CITY OF ALBUQUERQUE

December 15, 2011

Re: Fire Station No. 7, Grading and Drainage Plan

Engineer's Stamp dated 12-5-11 (K11/D079)

CITY OF ALBUQUERQUE PUBLIC WORKS DEPARTMENT ENGINEERING DEVELOPMENT GROUP			
TITLE: FIRE STATION 7 ALBUQUERQUE, NEW MEXICO GRADING AND DRAINAGE			
Design Review Committee	City Engineer Approval	Last Design Update	Mo./Day/Yr.
City Project No. 8006.91	Zone Map No. K-11	DWG. C-101A	Sheet 6 Of 13

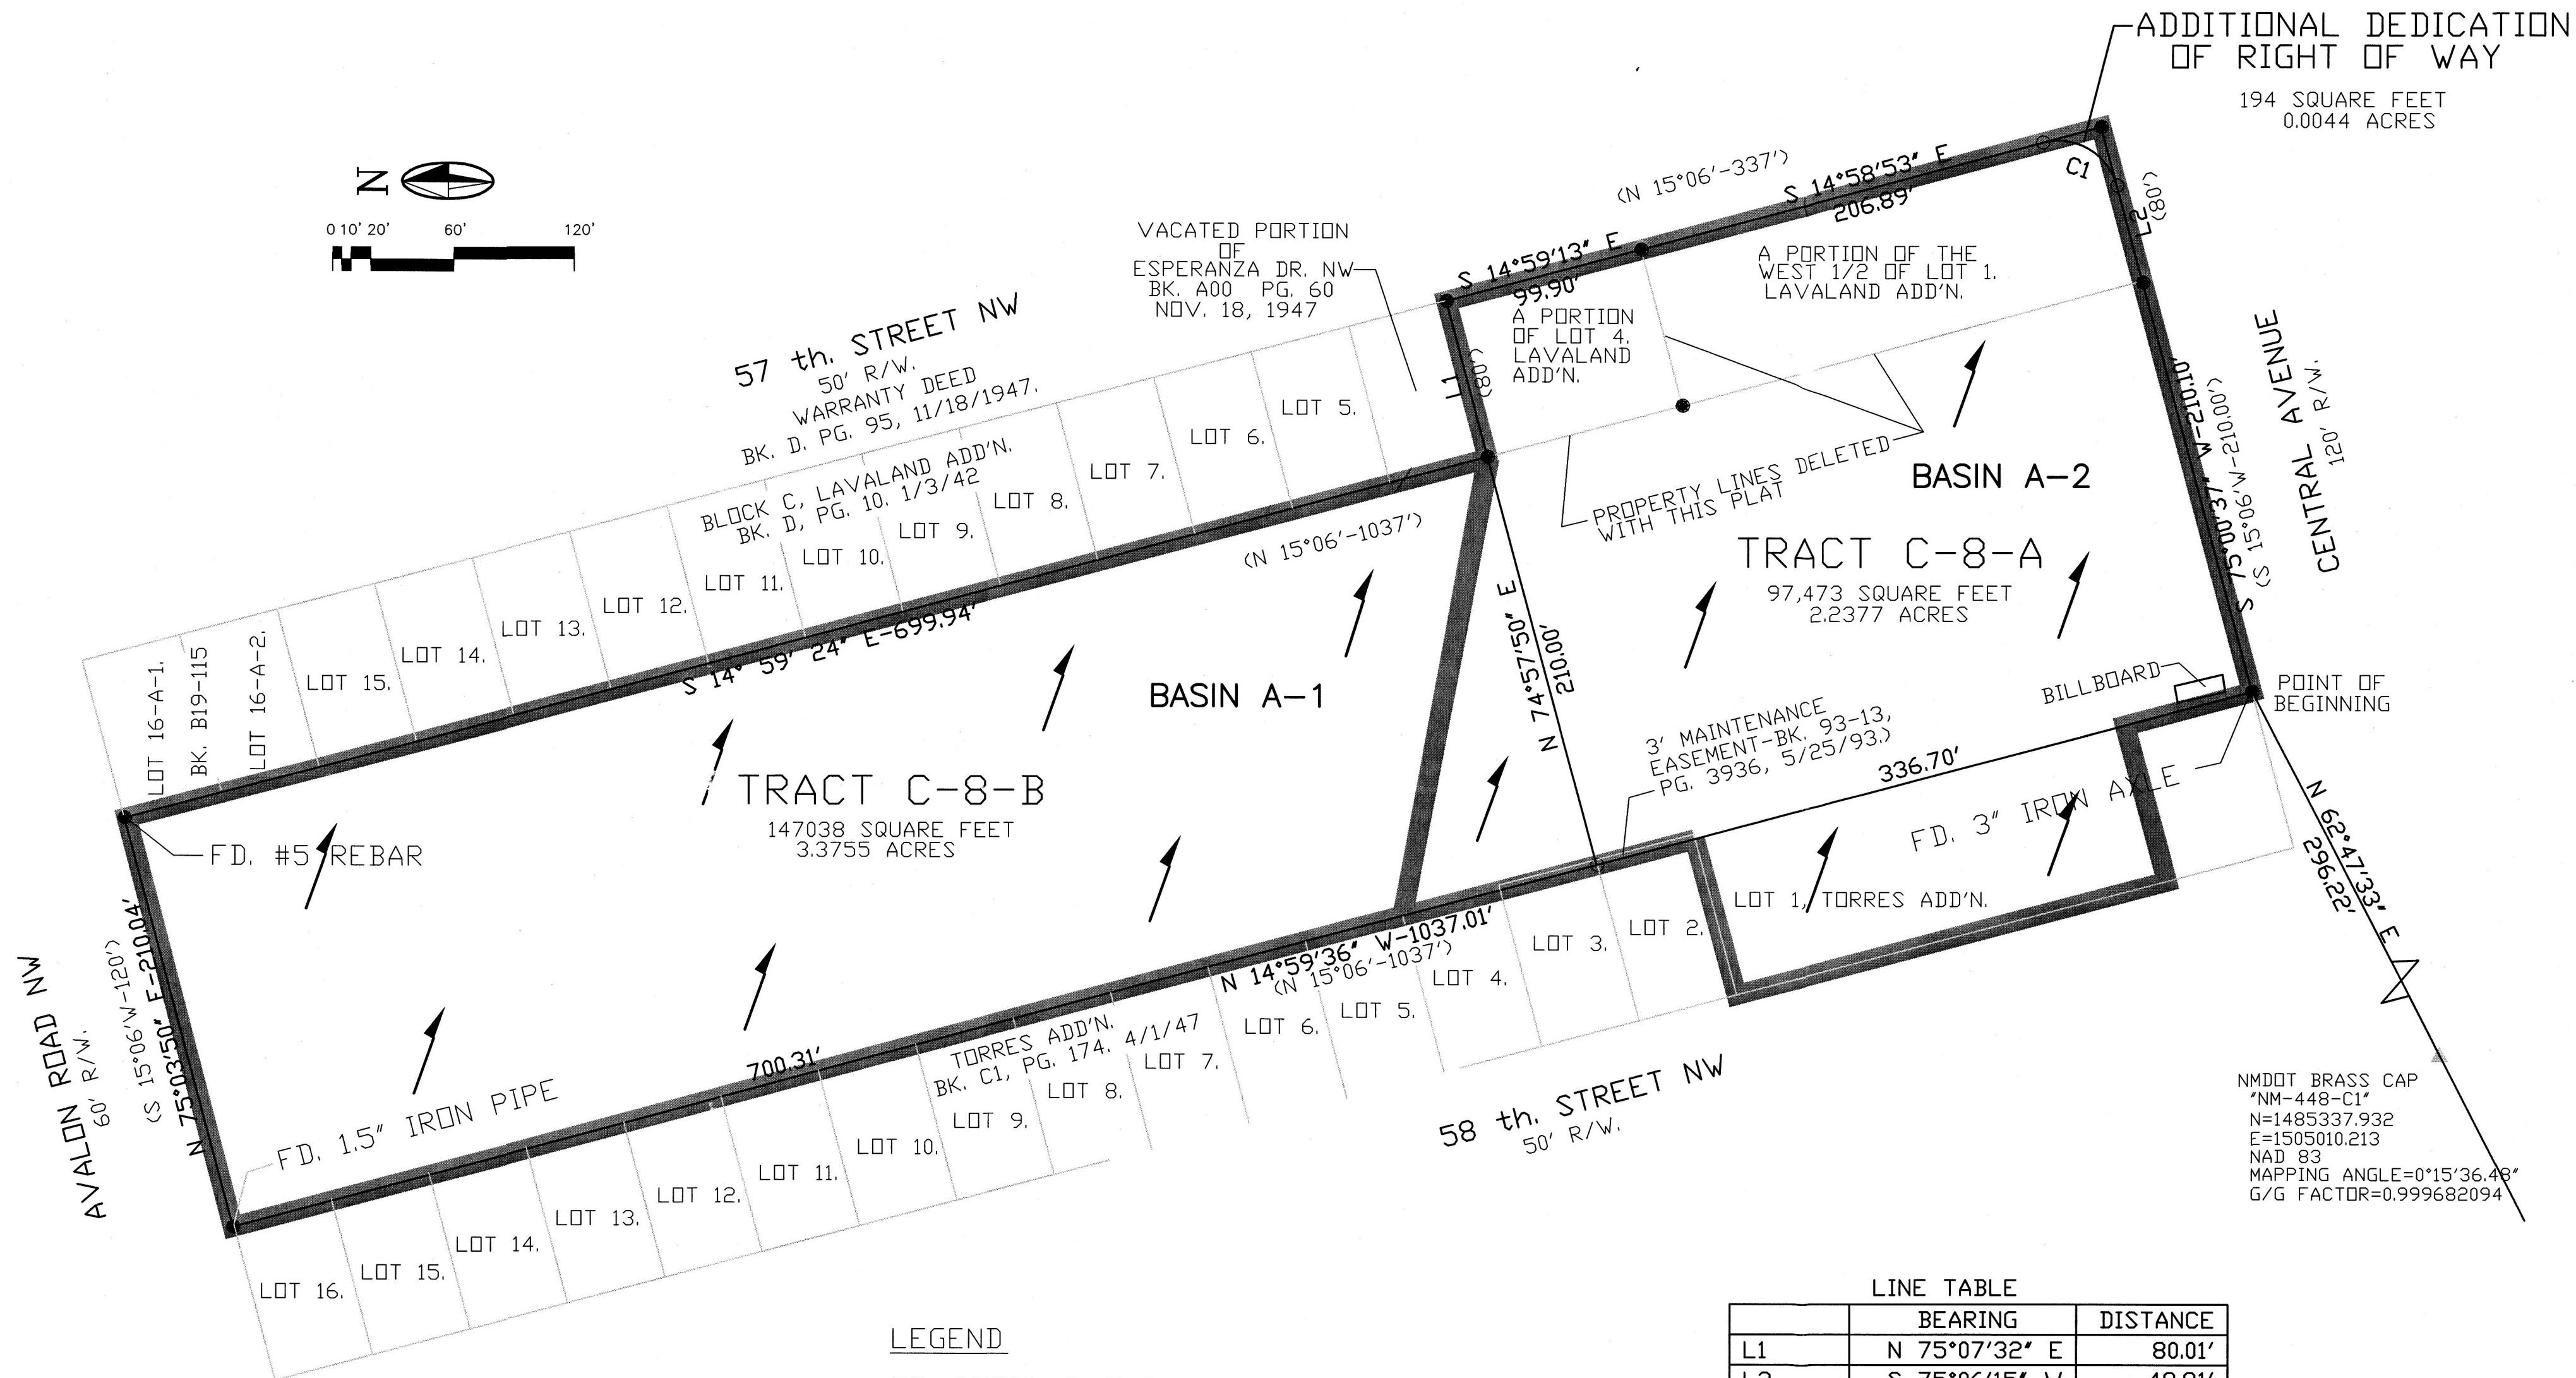
- Additional details/grades will be required including: TW/BW, spot elevations in the parking and drive areas, direction of roof flows, etc.
- Verify you have cover over the 18" storm drain under the east drive.
- It is beneficial to see existing spot elevations around the perimeter.
